Light Valley Solar

Written Summary of Applicant's Oral Submissions

Issue Specific Hearing 1

Document Reference: EN0110012/APP/LVS/08.08

Drawing Number
EN0110012/APP/LVS/06.02.11.02.05

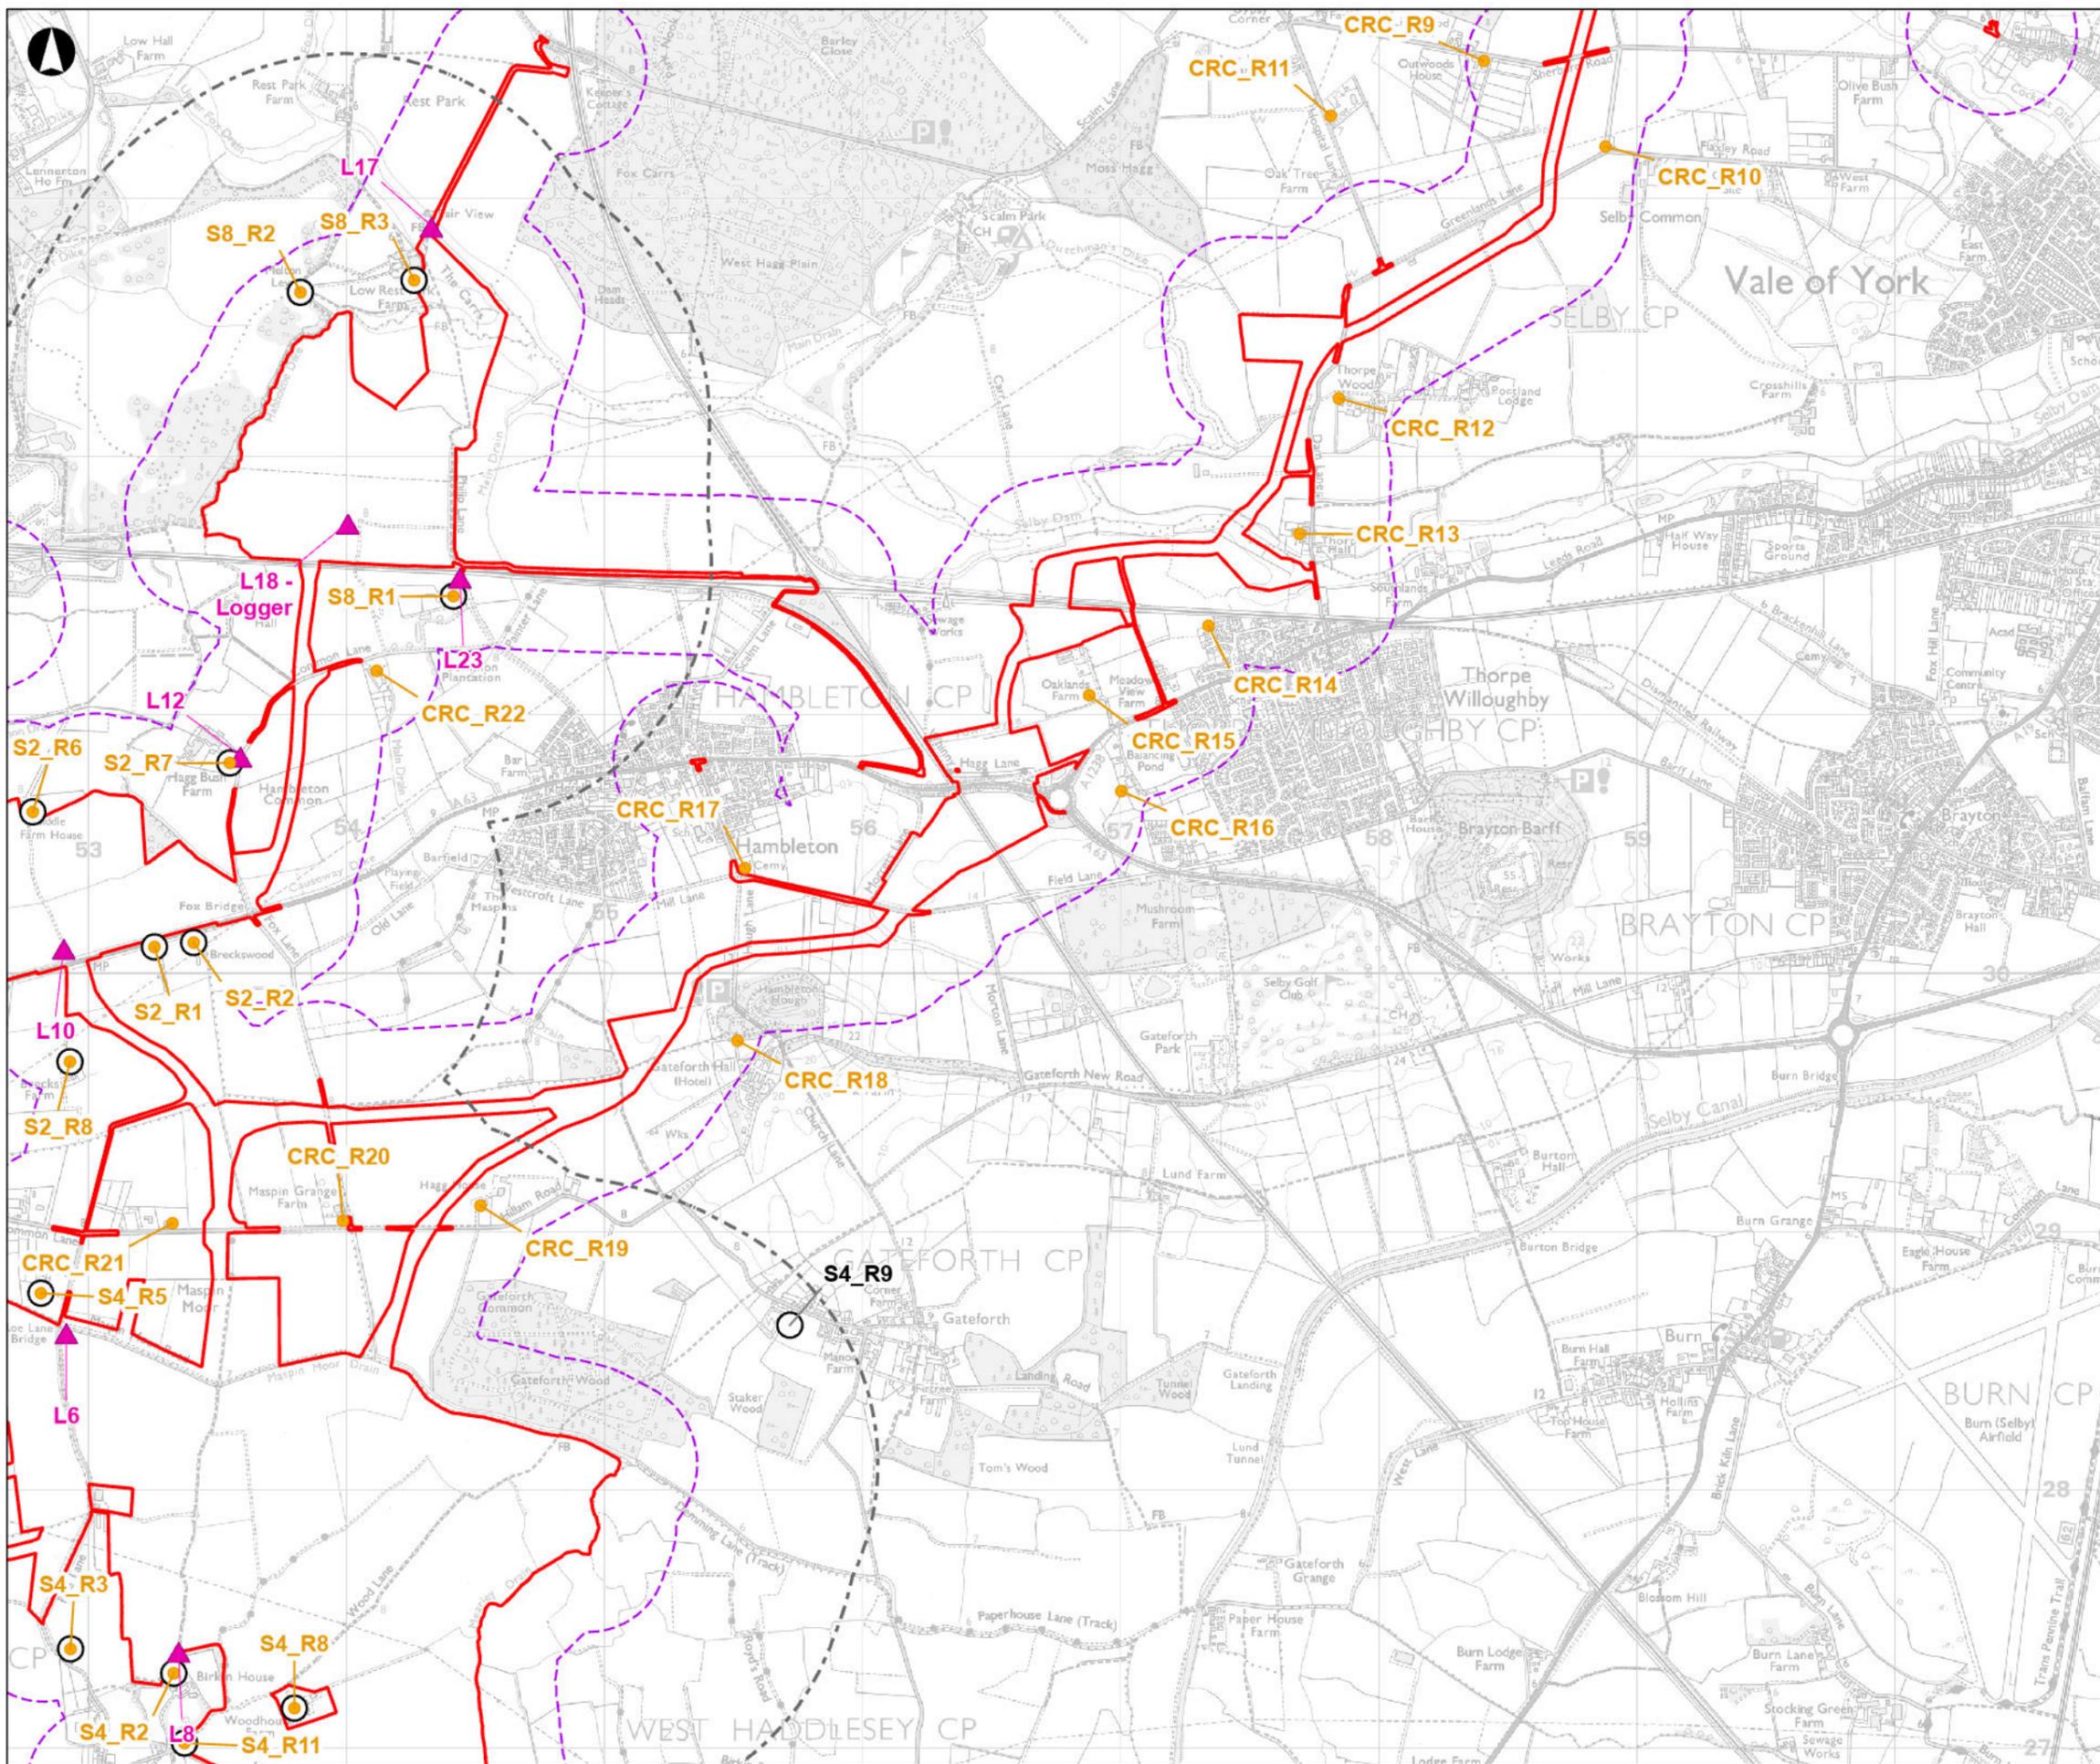
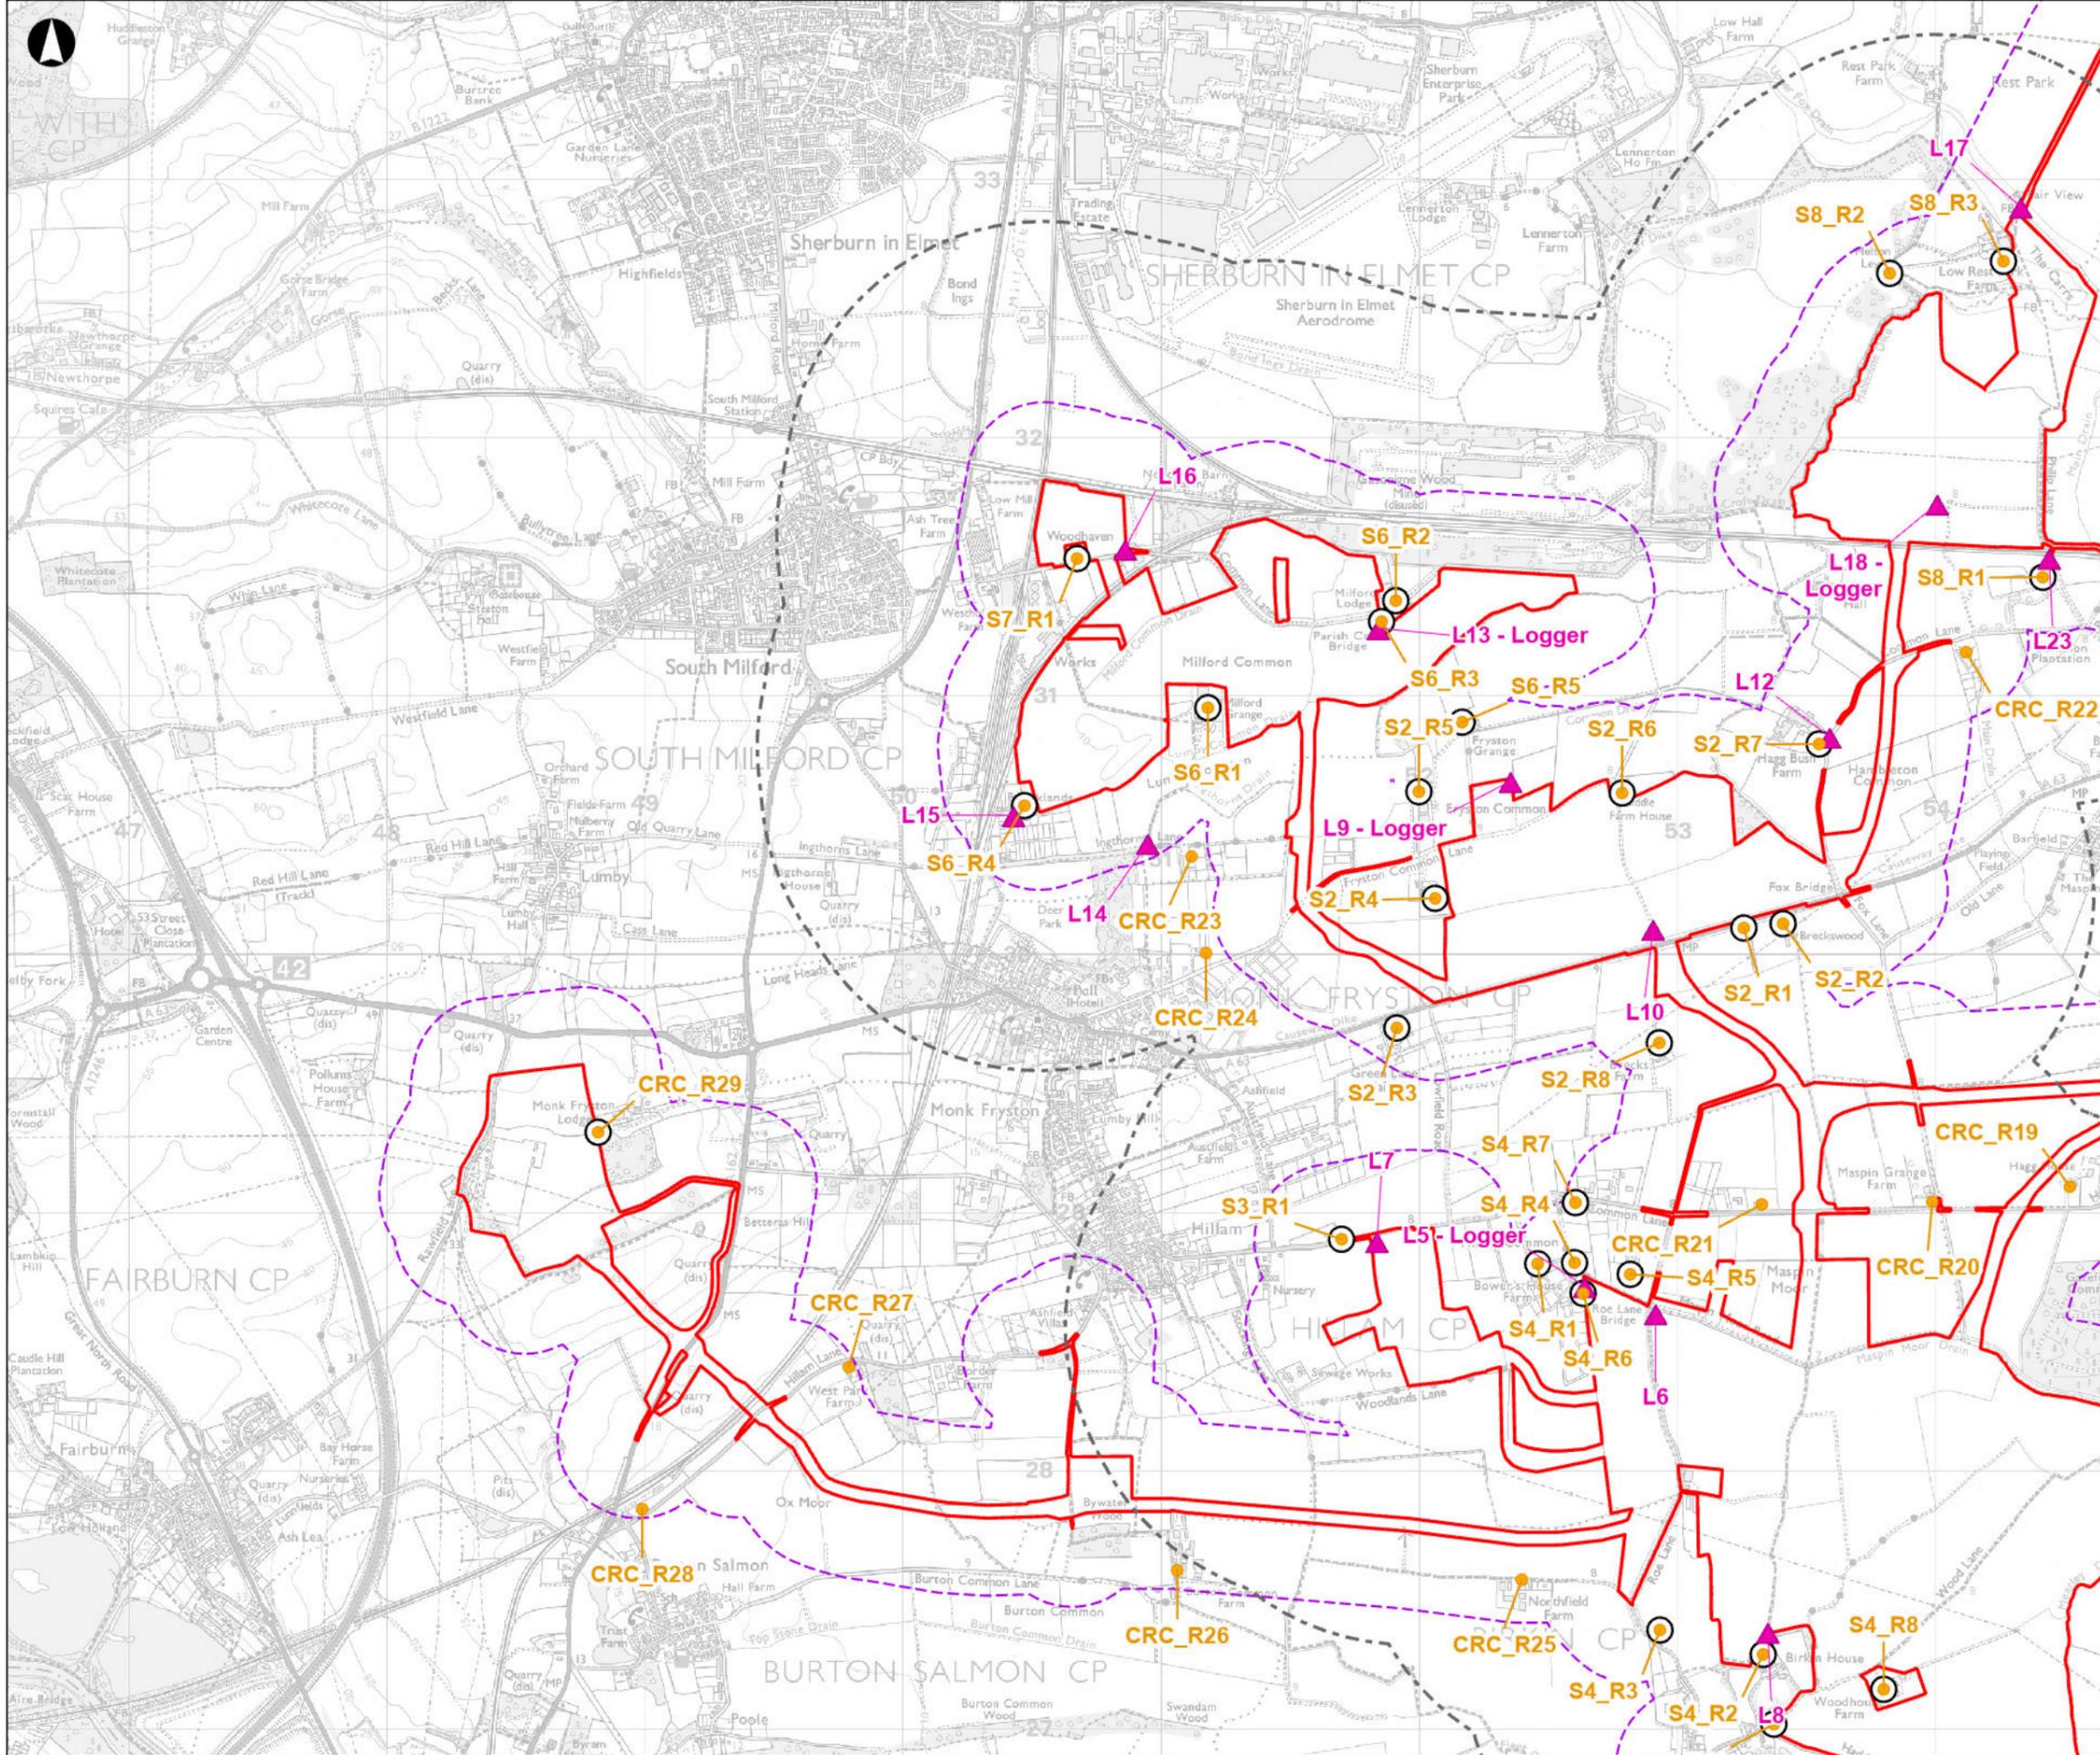
#	Agent Item	Written Summary of the Applicant's Oral Submissions
		<u>Tonality</u> The ExA asked the Applicant to explain the following: ▪ How residential receptors have been assessed with reference to Appendix 11.3 [APP-173]; ▪ How the characteristics of tonality, intermittency, and impulsiveness have been considered within the assessment; ▪ Whether those characteristics could materially alter the perceived impact on nearby receptors; and ▪ How the applicant proposes to introduce future controls on operational noise at residential receptors. <u>Assessment methodology</u> In respect of the sound level, Mr Hiller confirmed that 91dB mentioned at the Open Floor Hearing is from Table 2.1 of ES Appendix 11.3 [APP-173] and this is a sound <u>power</u> level. The Applicant explained that sound power levels characterise the output of a source. Those levels are inputted into three-dimensional noise mapping software which then predicts the sound levels arising from the site at all assessed receptors. These calculations are then interrogated to show the likely noise <u>impacts</u>. Mr Hiller confirmed that the assessment of operational noise has been carried out in accordance with British Standard 4142 (Methods for rating and assessing industrial and commercial sound), which is the appropriate standard for noise sources of a commercial or industrial character. This is applied to building services plant and associated equipment. He submitted that this standard is equally applicable to the sources proposed in the Proposed Development. The approach involves comparing the predicted noise from the plant against the background sound level at each receptor, assessed separately for daytime and night-time conditions. Baseline sound levels have been established from an environmental sound survey using noise loggers deployed at

#	Agent Item	Written Summary of the Applicant's Oral Submissions
		various locations, illustrated in Figure 11.2 of the Environmental Statement [APP-099]. The tabulated impact assessments following the BS 4142 methodology are set out in ES Appendix 11.3 [APP-173]. Mr Hiller confirmed that the Applicant had assumed a 4 dB correction (tonality penalty) for the predicted sound levels from all assessed equipment. This penalty is taken from British Standard 4142 and is representative of what the standard describes as "clearly perceptible tonality" in the sound as perceived at the receptor. Intermittency in this aspect would not be relevant as the equipment will operate in a continuous manner whilst running, rather than switching rapidly on and off over short time periods. Accordingly, an intermittency correction has not been applied. Moreover, Mr Hiller explained that tonality affects people's perception of sound without necessarily producing a higher absolute noise level. By applying the tonality penalty when calculating the rating level, the assessment produces a more representative evaluation of the impact on people's perception of the noise, rather than relying solely on the raw sound level. The Applicant did not identify impulsiveness as a characteristic applicable to the operational noise sources in this development. No impulsiveness correction has been applied. <u>Future controls on Operational Noise</u> The applicant acknowledged that the level of control that can be applied to tonality cannot be fully assessed until the individual items of plant are understood in detail. For the purposes of the assessment, it has been assumed that tonality may or may not be perceptible at receptors. There are a number of sources for each of those so tonalities may or may not be perceptible as the noise from the sources may attenuate to the point where it is inaudible against the background soundscape. Mr Hiller noted that, for example attenuators could be fitted onto conversion units to reduce sound levels where needed. These can be used to control frequency content if necessary. Moreover, it has
